From: Nicola Spencer on behalf of Planning.Responses
Sent: 01 March 2018 13:01
To: Karen Garner
Subject: FW: AL/5/18/RES Woodgate Farm - revised drawings
Attachments: 17-01-102-P3_Woodgate Farm_Site Block Plan with Visibility Splay.pdf; 17-02-201-P2_Woodgate Farm_GF Plan.pdf; 17-02-202-P2_Woodgate Farm_1st Floor Plan.pdf; 17-02-203-P2_Woodgate Farm_2nd Floor Plan.pdf; 17-02-204-P2_Woodgate Farm_Roof Plan.pdf; 17-03-301-P2_Woodgate Farm_North & South Elevations.pdf; 17-03-302-P2_Woodgate Farm_West & East Elevations.pdf; 17-00-500-P2_Woodgate Farm_3D views.pdf; 17-01-101-P4_Woodgate Farm_Site Plan with Landscape.pdf

From: Simon Davis
Sent: 28 February 2018 16:04
To: Planning.Responses
Subject: FW: AL/5/18/RES Woodgate Farm - revised drawings

I write further to our recent submission for the reserved matters approval at the site to the rear of Woodgate Farm, Westergate.

title: Site Block Plan with Visibility Splay

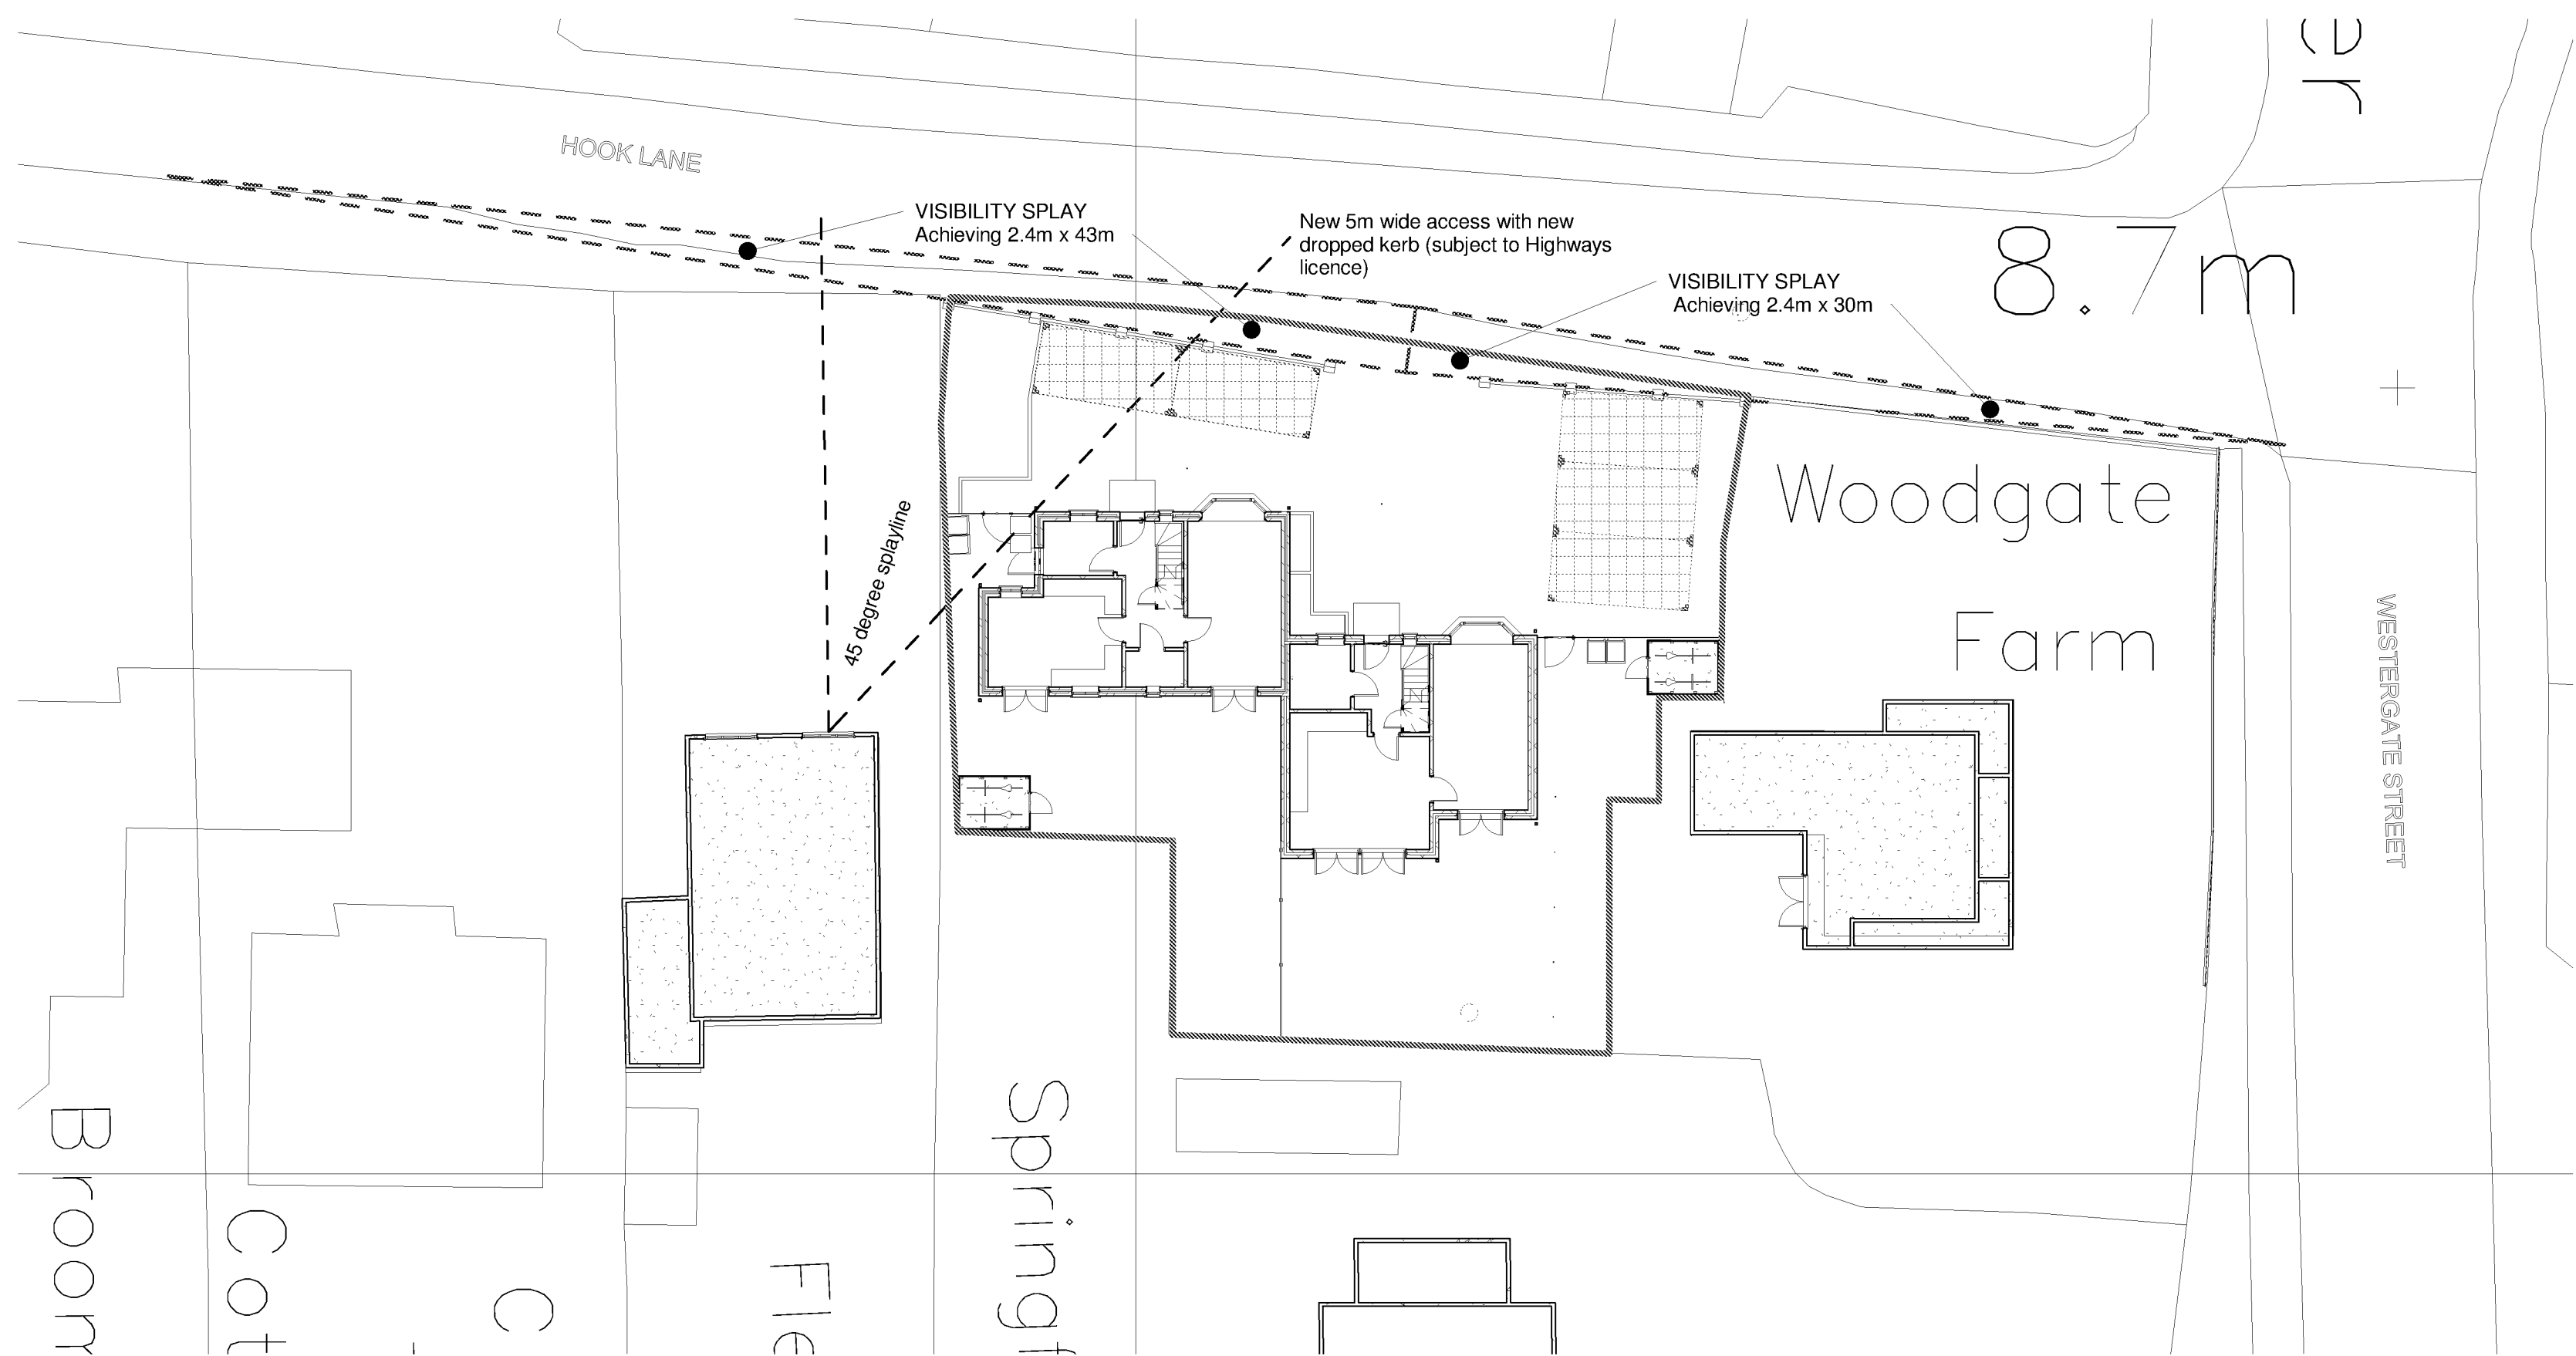
We have also addressed the query relating to the unallocated visitor bay, which is now marked as the bay nearest the road. These bays are now of adequate size.

title: Ground Floor Plan

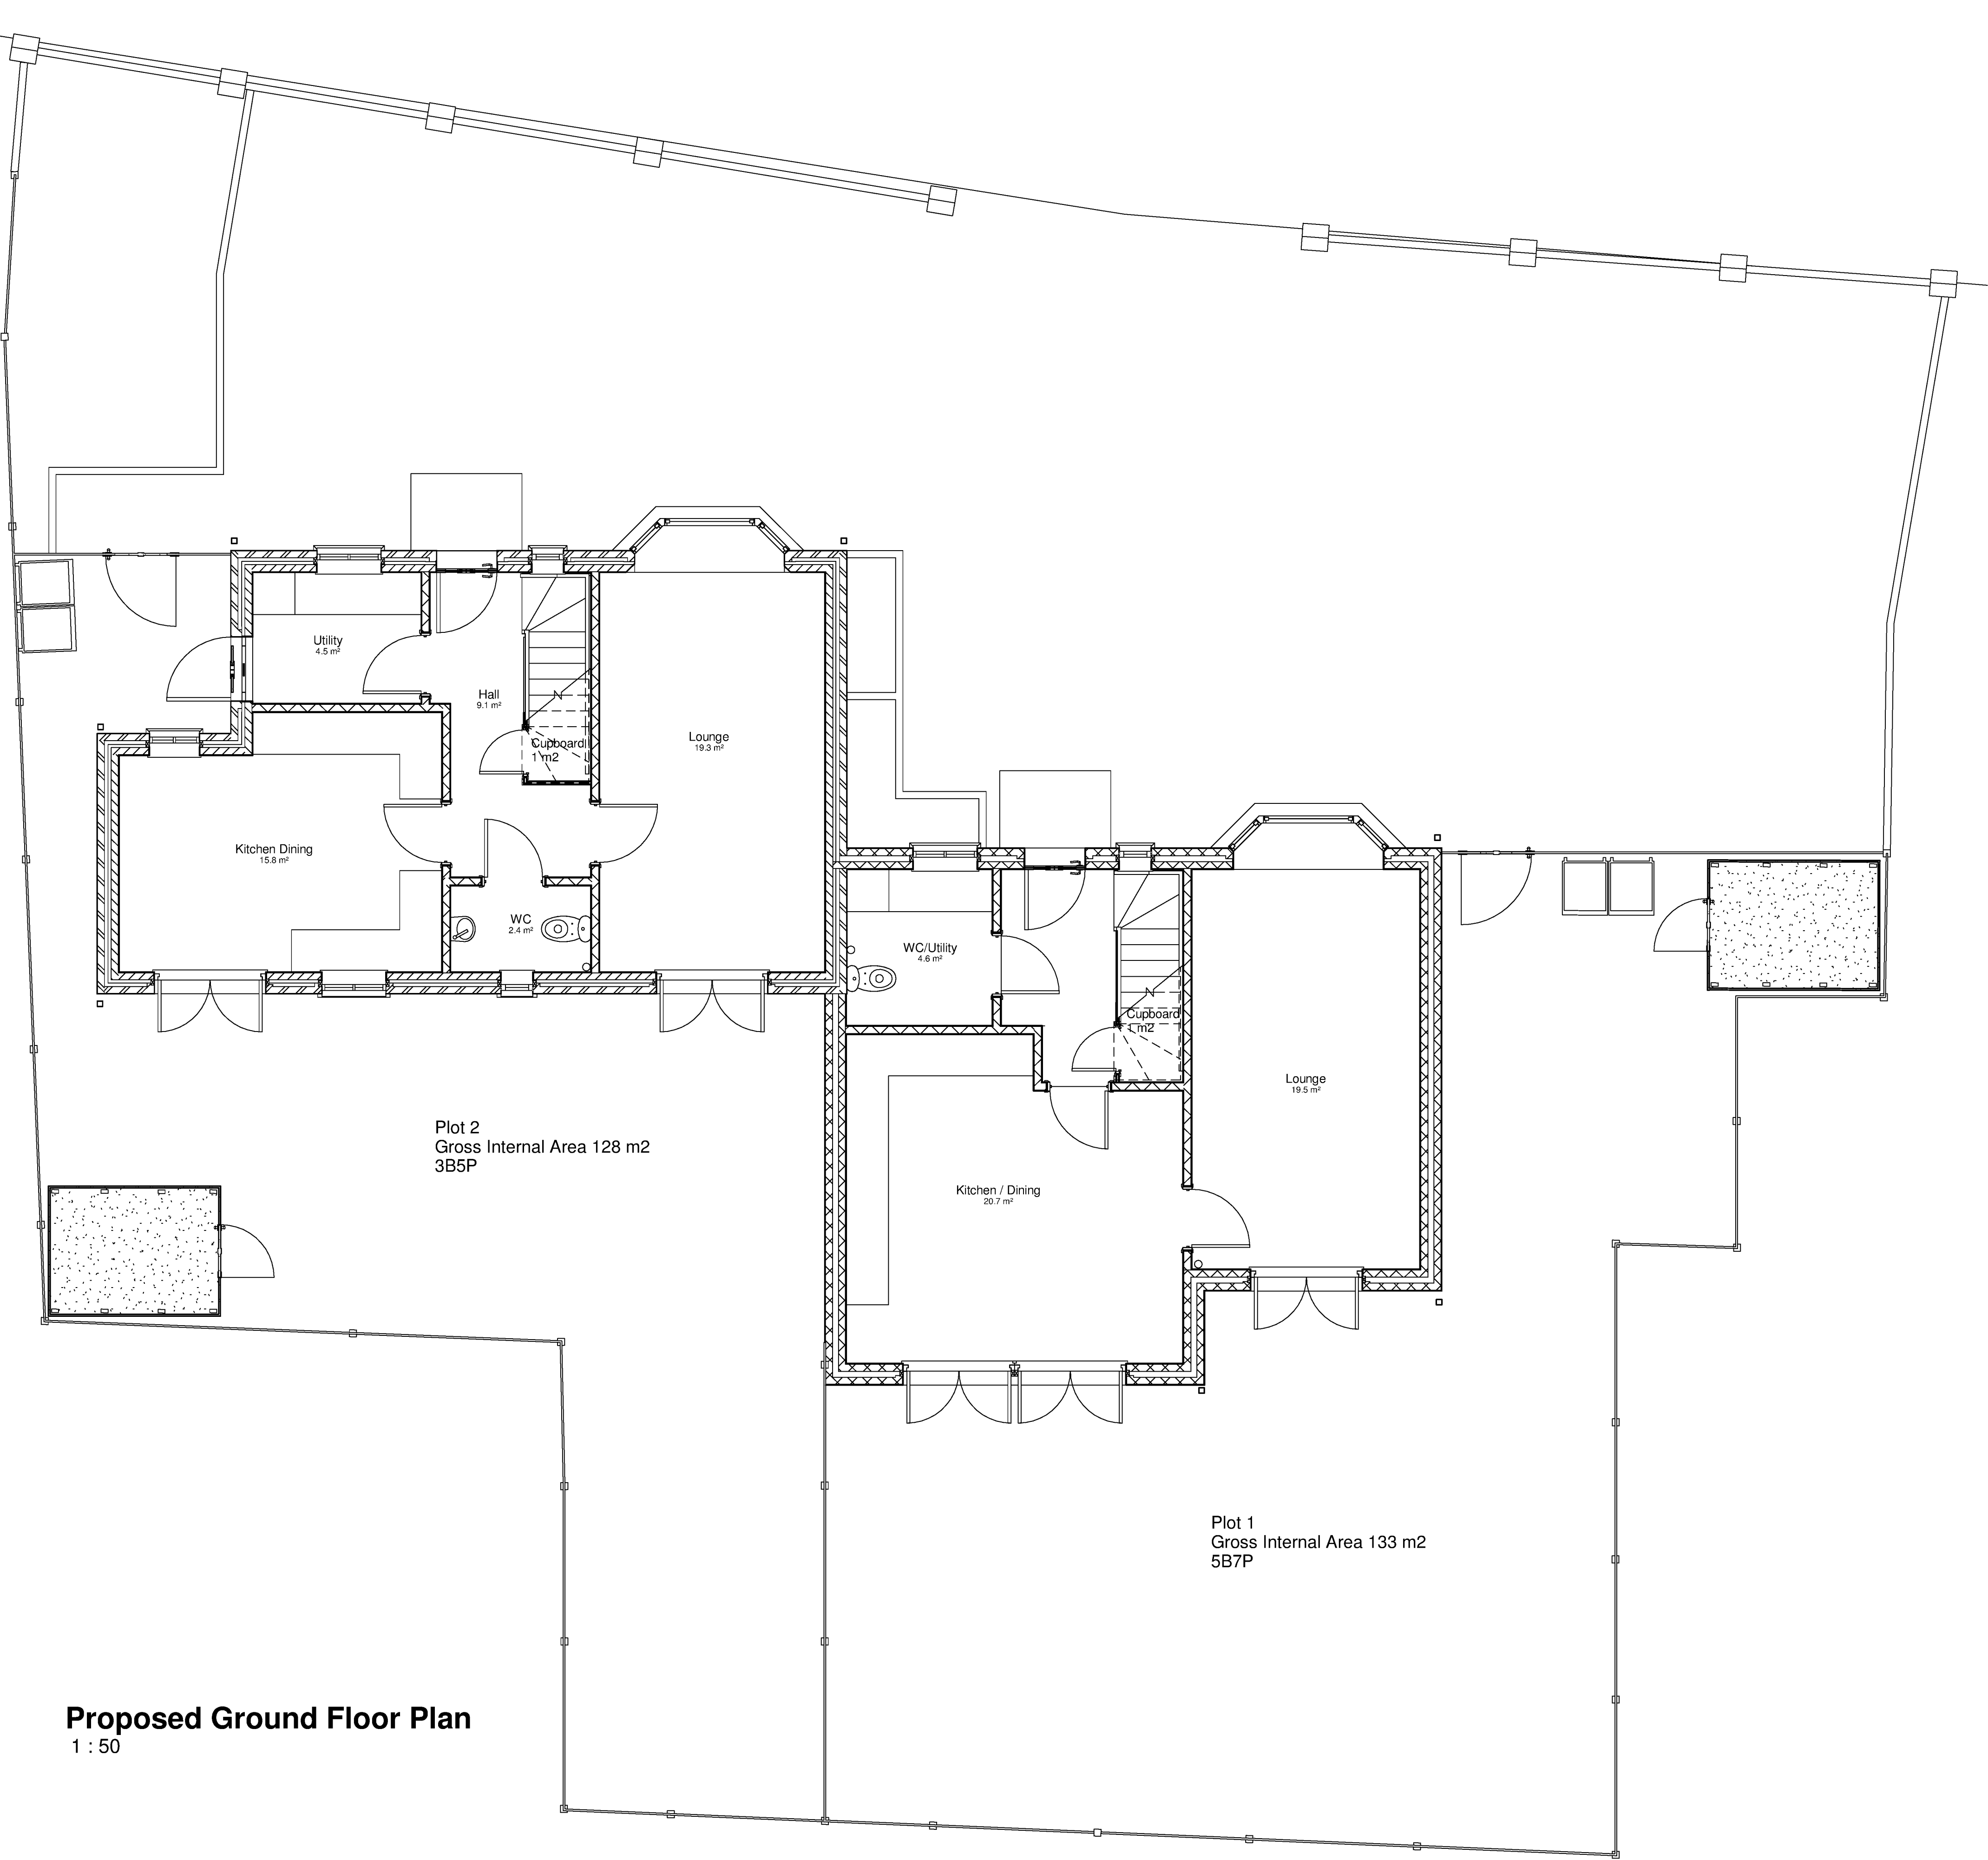
Plot 1;

Adjusted 450mm backwards to allow greater space at front for parking area.

Fanlight added above front door & porch amended for canopy.

Introduction of bay window to Living room.
Removal of French doors to east elevation.
Introduction of Utility area at ground floor.
Reduced width on rear doors to allow kitchen units.
Reconfiguration of master ensuite/dressing.
Introduction of WC to second floor.
Front elevation amended from half-rendered to full rendered.
Introduction of stone cills under windows, brick soldiers over.

Plot 2;
Fanlight added above front door & porch amended for canopy.
Introduction of bay window to Living room.
Introduction of Utility room at ground floor.
Swapping kitchen ground floor window and doors to allow for revised kitchen layout.
Re-alignment of master dressing room window to be central and resulting utility room window below.
Introduction of WC to second floor.
Introduction of stone cills under windows, brick soldiers over.

title: West & East Elevations

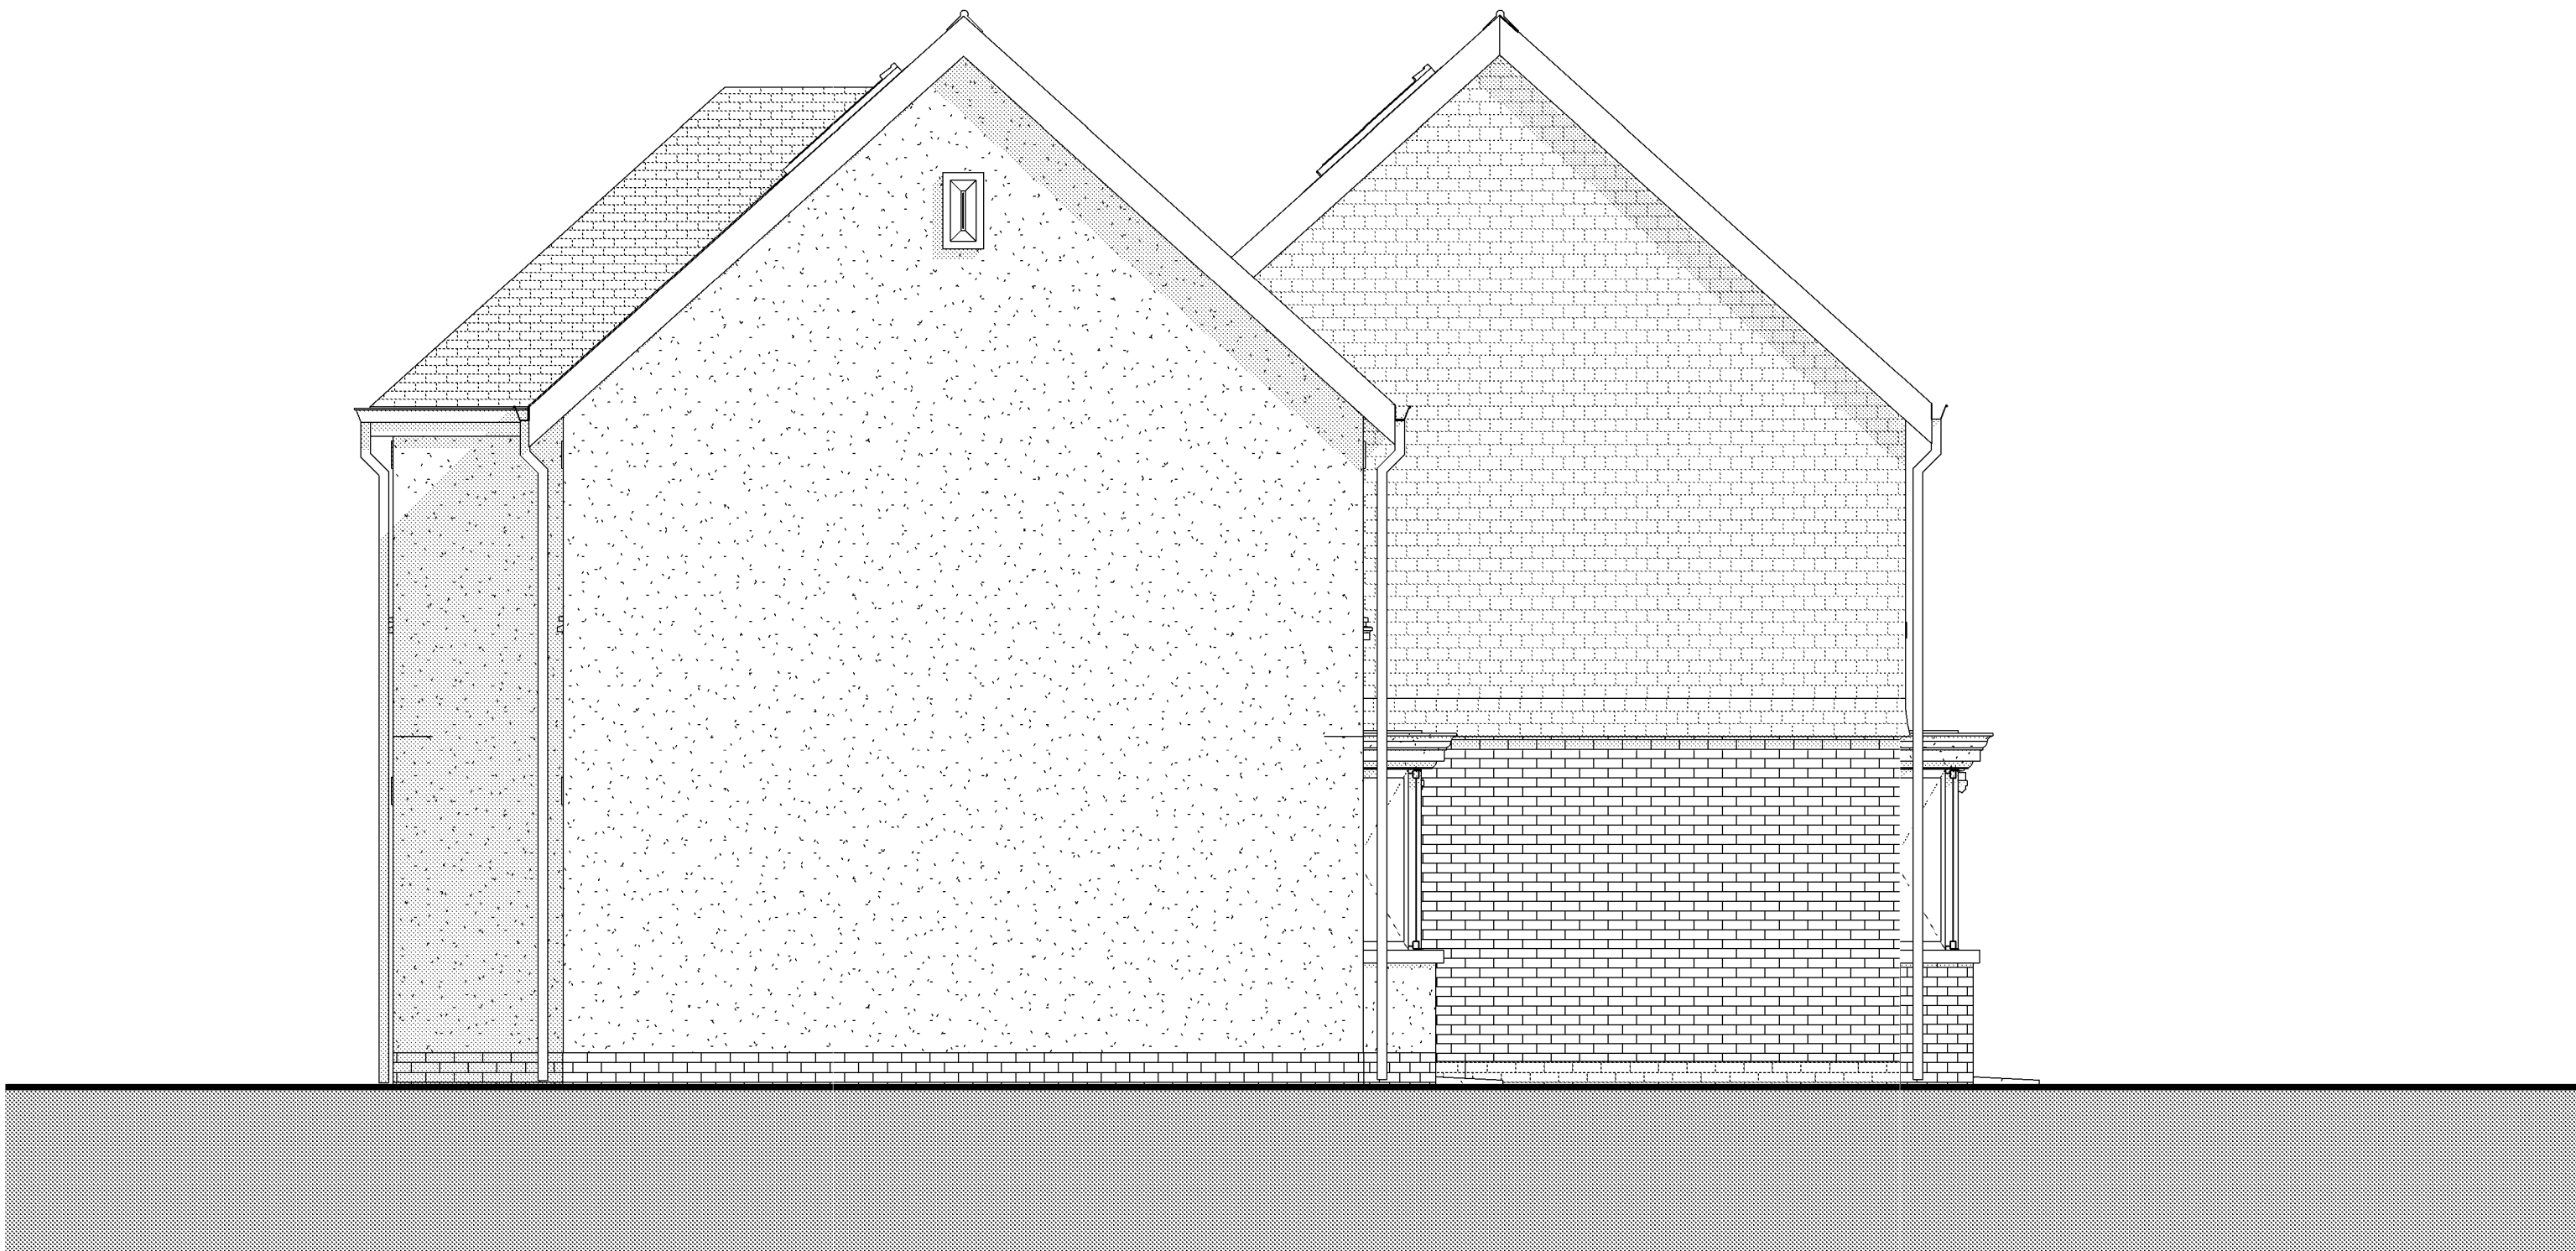
Yes the changes do result in some changes to the elevations also, we couldn't list too much in the revision box but perhaps should have put slightly better description. For clarity, the changes are as follows;
